**CITY OF PORTLAND, MAINE
DEVELOPMENT REVIEW APPLICATION
PLANNING DEPARTMENT PROCESSING FORM
Engineering Copy**

Bay Street Extension
Project Name/Description

PUBLIC WORKS ENGINEERING REVIEW..7/18/03

I have reviewed the plans and application dated 7/16/03 and offer the following comments:

**PLAN & PROFILE**  
 9+30-12+06  
 BAY STREET EXTENSION  
 BAY STREET  
 PORTLAND, MAINE  
 JOHN SARGENT  
 HERBERT P. GRAY  
 111 SIMMONS ROAD, SOUTH PORTLAND, MAINE 04106  
 SCALE: HOR 1"=20' VERT 1"=4' DWG. NO.  
 DATE: 3/04/05  
 DRAWN BY: DHG  
 CHECKED BY: HPG  
 3 OF 4

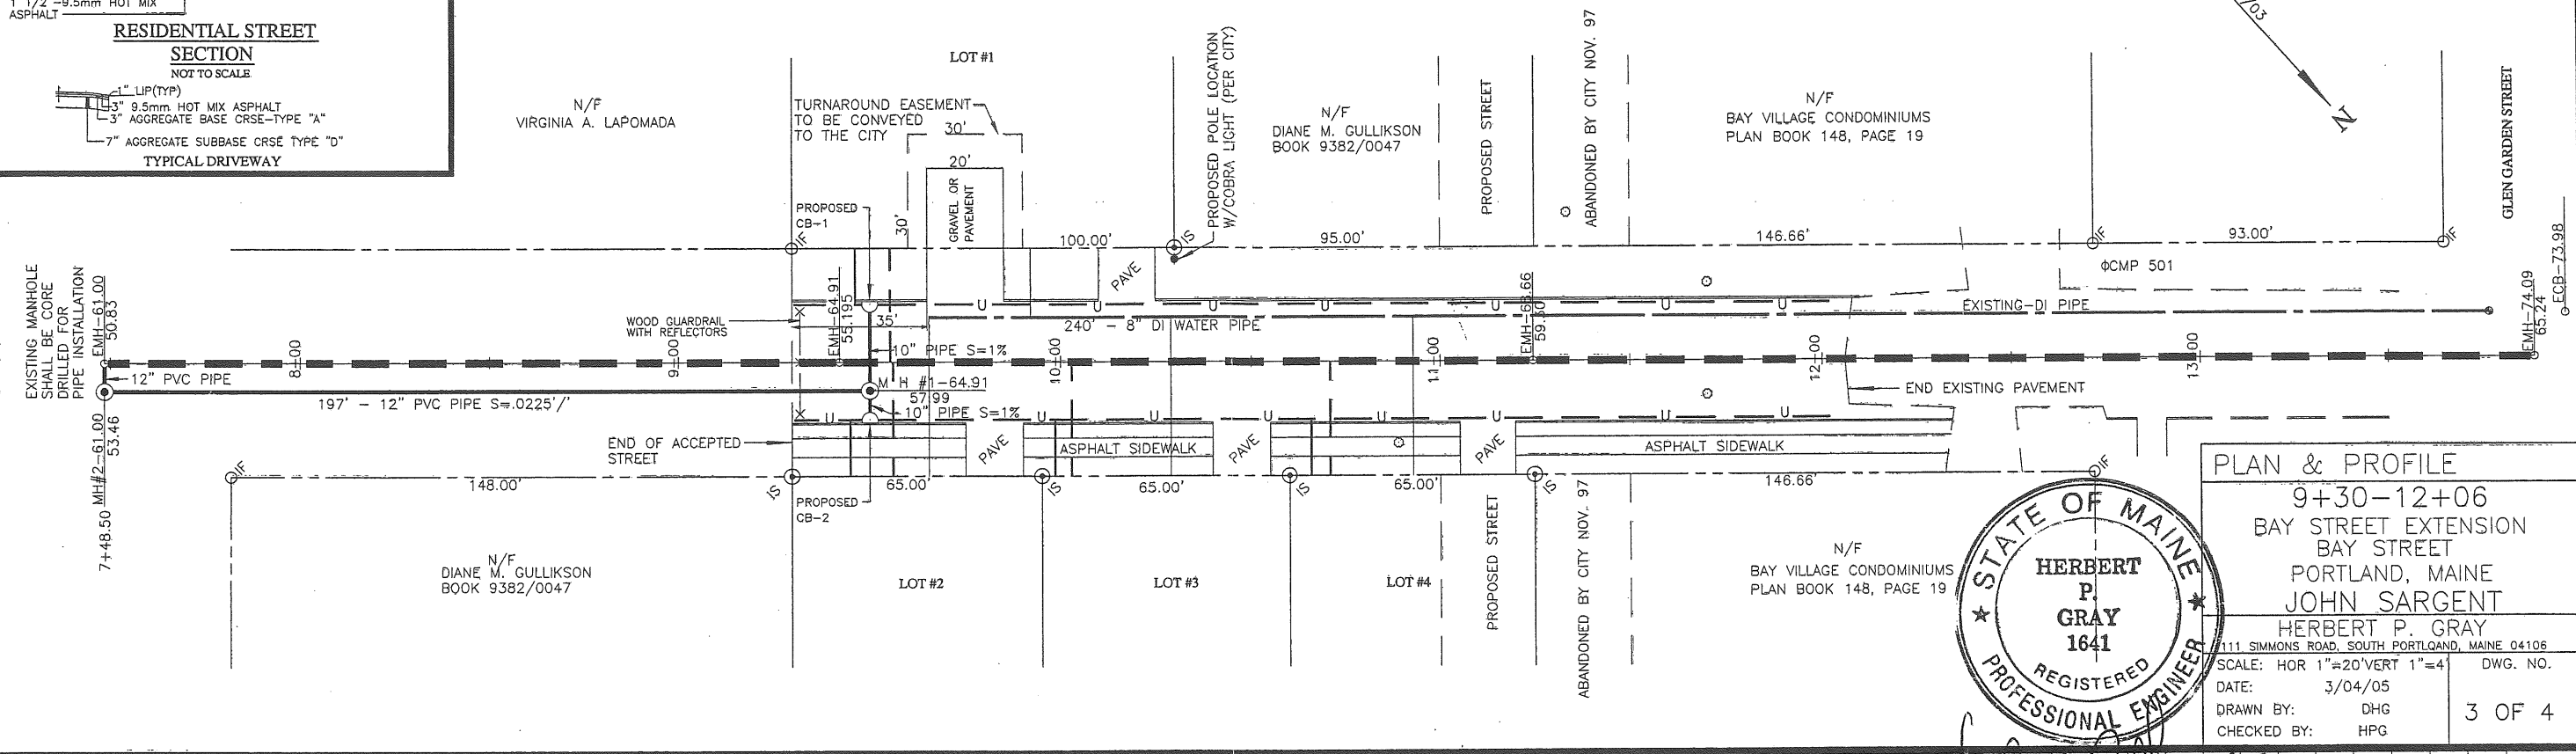
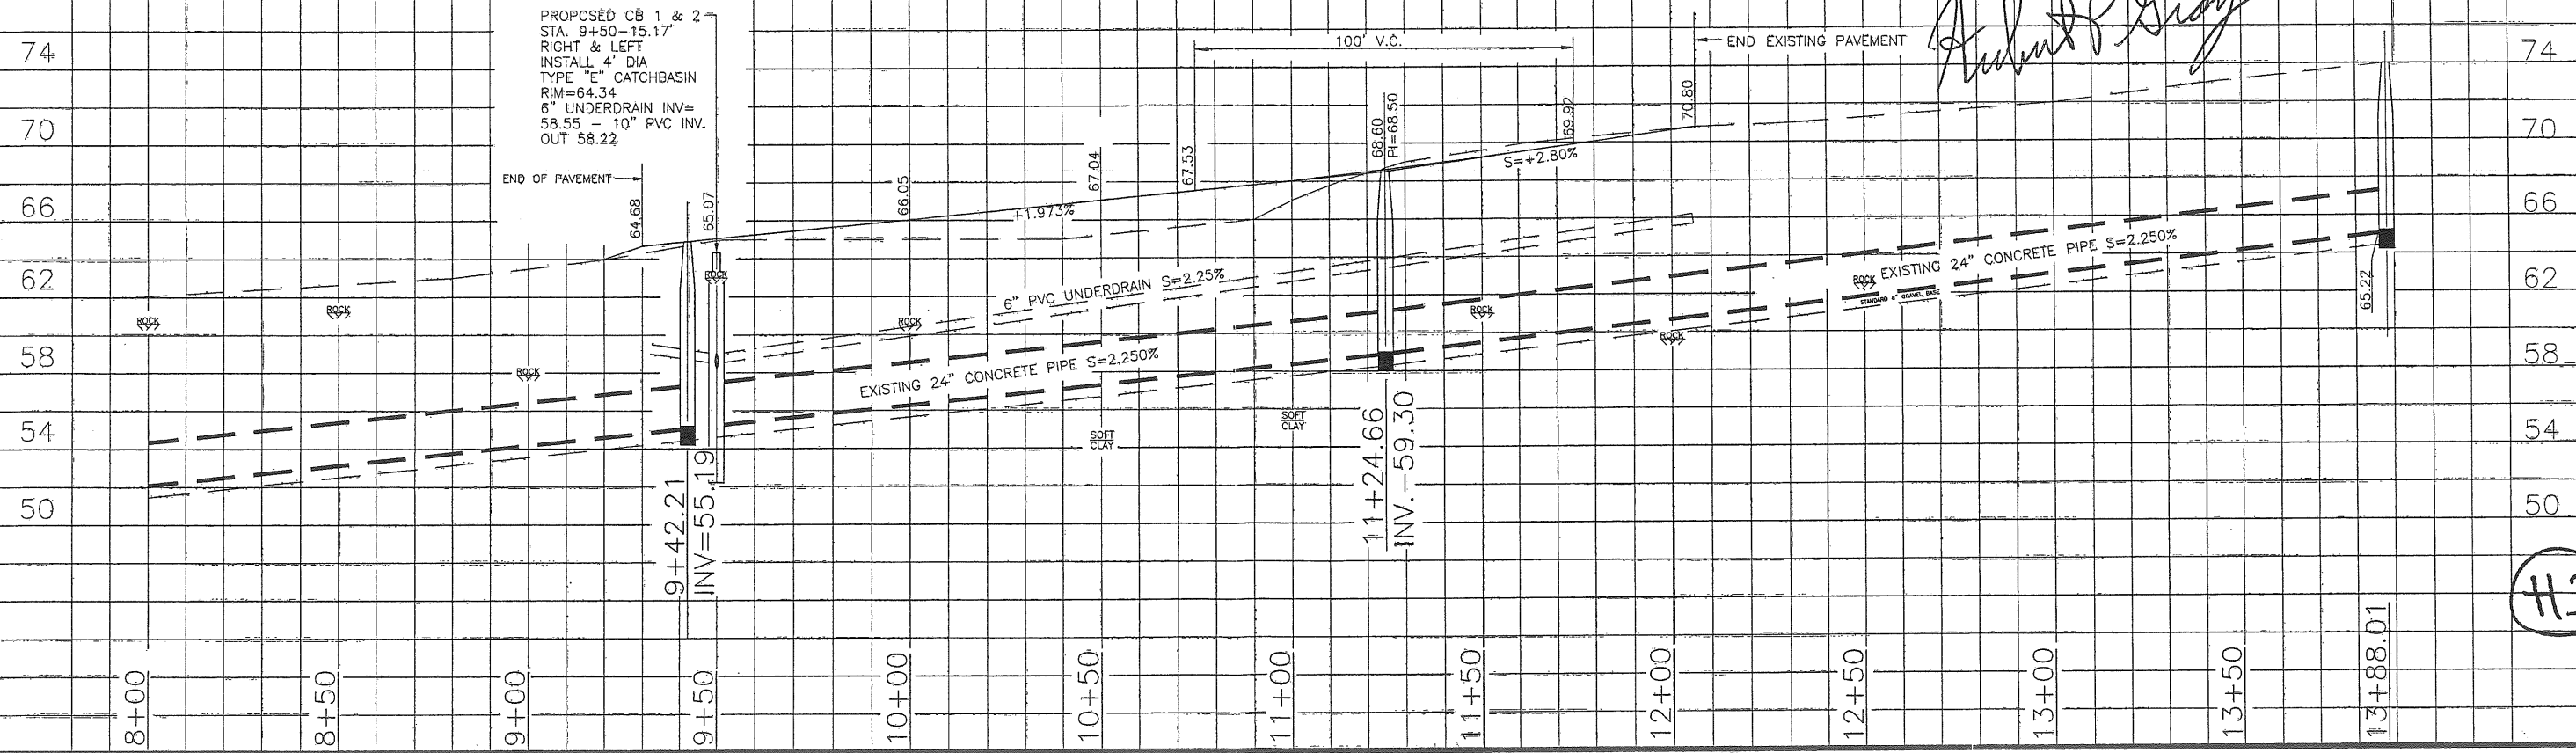
- The plans should specify proposed utility service stubs to the vacant developable lots owned by the developer.
- Driveway entrances should also be specified for the buildable lots.

- The guardrail proposed at the end of the extended roadway is physically too close to the proposed catch basins and represent a maintenance issue for servicing the structures as well as plowing the roadway in the winter. Public Works is requesting the applicant extend the roadway an additional ten (10) feet, install granite tipdown terminal curb beyond the catch basin headstones and then install the proposed guardrail. The plans should specify a construction detail for the guardrail.

INSTALLATION OF CURB  
NOT TO SCALE

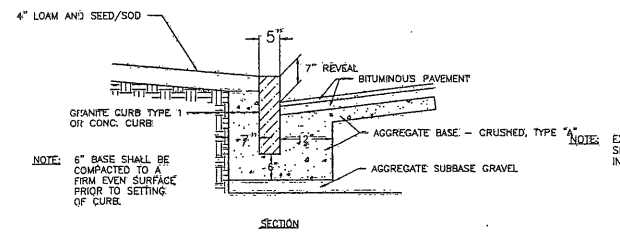
- A construction detail is required for granite curb installation and sidewalk construction.
- The plans must specify that the connection of two proposed catch basins into the existing manhole at end of the extend paved surface, must be created by "core drilling" into the existing manhole. Further, these new inverts must be fitted with flexible connections.
